From: [Rachael Stevie \(CD\)](#)
To: [Candie Leader](#)
Subject: BL-20-00030 US Bureau of Reclamation - Request for Survey Review (2)
Date: Monday, February 1, 2021 11:36:00 AM
Attachments: [image002.png](#)
[image003.png](#)
[1702303_BLA.pdf](#)
[BLA LOT DESCRIPTIONS.docx](#)

Please see the revised final survey for BLA-00030.

My responses to the Kittitas County comments regarding BLA BL-20-00030 are as follows:

BOUNDARY LINE ADJUSTMENT FOR U.S. BUREAU OF RECLAMATION
DRAWN BY: KDB DATE: 6/1/2020 REV. BY: KDB DATE: 2/01/2021 PROJECT MANAGER: KDB SCALE: 1" = 1000'
DRAWING FILE NAME: 1702303_BLA.DWG CHK BY: SPJR JOB NO. 17-023-03 SHT. NO. 1 OF 6

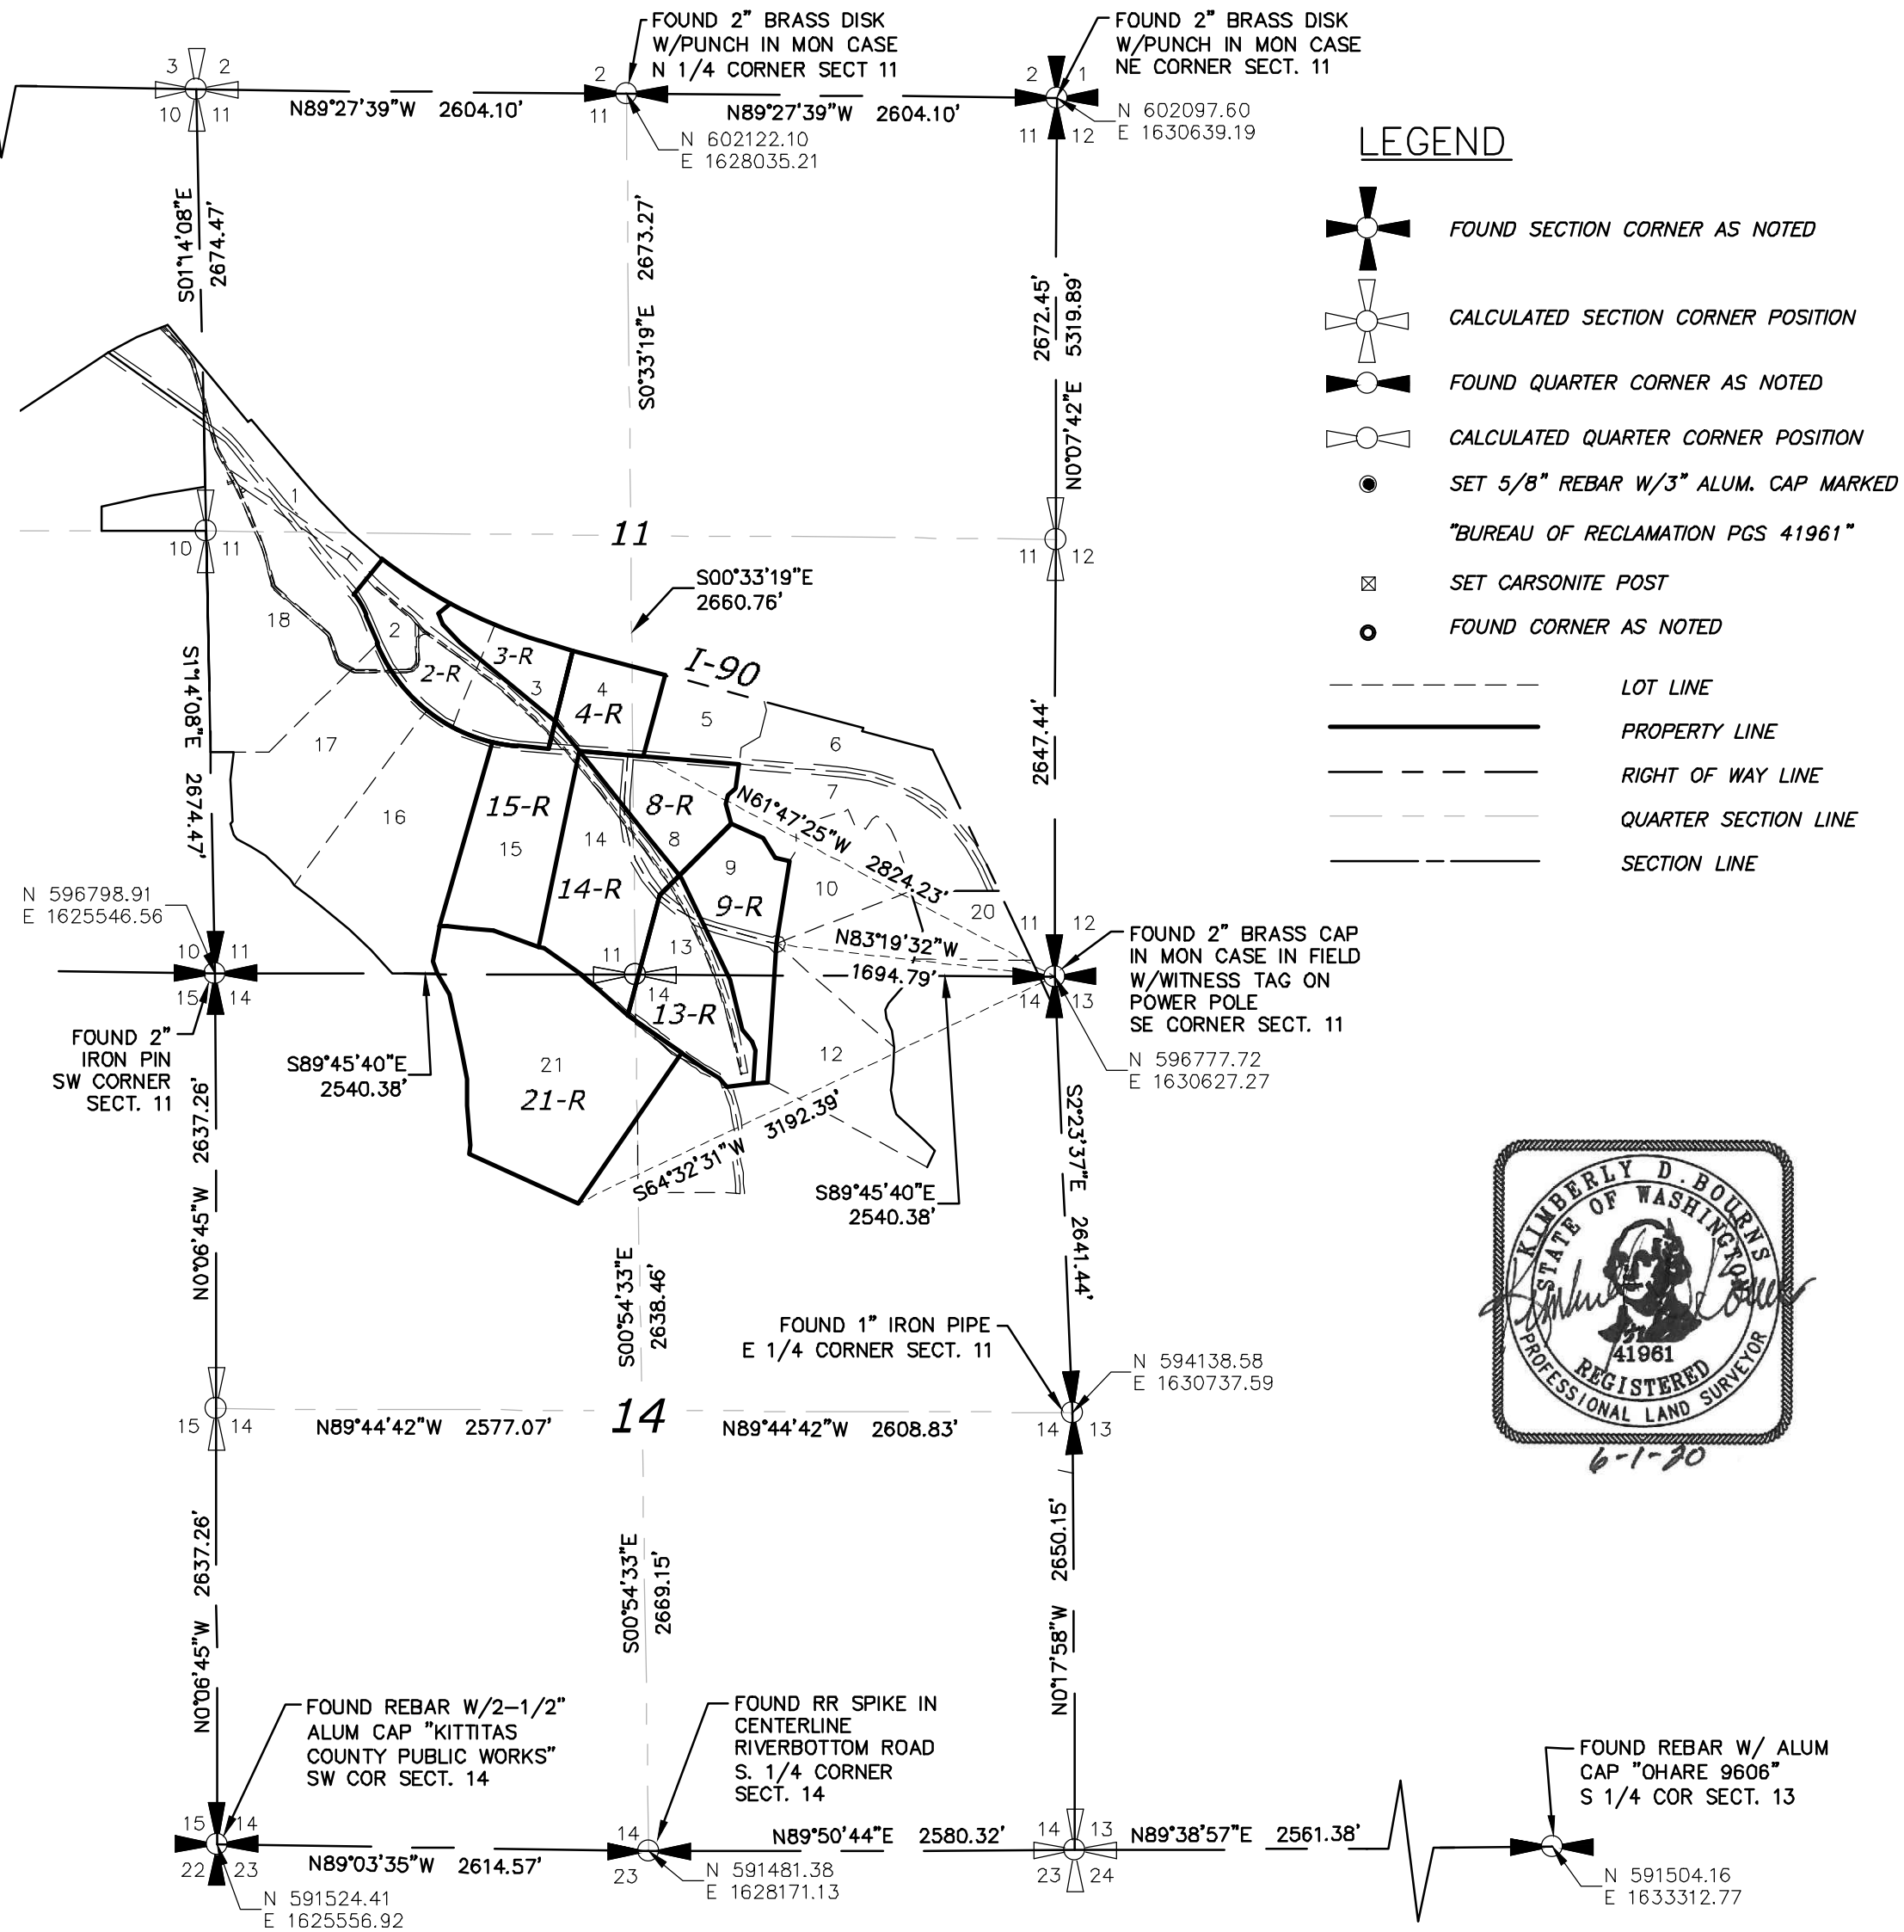
- Item 1, page 1 – all access easements are shown on the face of the BLA map, resolving the access to lots 16 and 17.
- Item 1 page 2 – References to Lot 21 and application BL-20-00030 were added to the survey narrative.
- Item 2 page 2 – Surveyor's Certificate was revised to list U.S. Bureau of Reclamation as the client.
- Item 3, page 2 – Crows feet were added to the curve on the south boundary of Lot 2-R to clarify dimensioning.
- Item 4, page 2 – Bearing and distance were added to NE line of lot 15-R.
- Item 5, page 2 – All new legal descriptions were edited to read "LOT ____ OF THAT CERTAIN SURVEY RECORDED _____, 2021, IN BOOK _____, PAGE _____, UNDER AUDITOR'S FILE NO. _____, RECORDS OF KITTITAS COUNTY." The blanks for the legal descriptions and the PUD easement will be filled in at the time of recording.
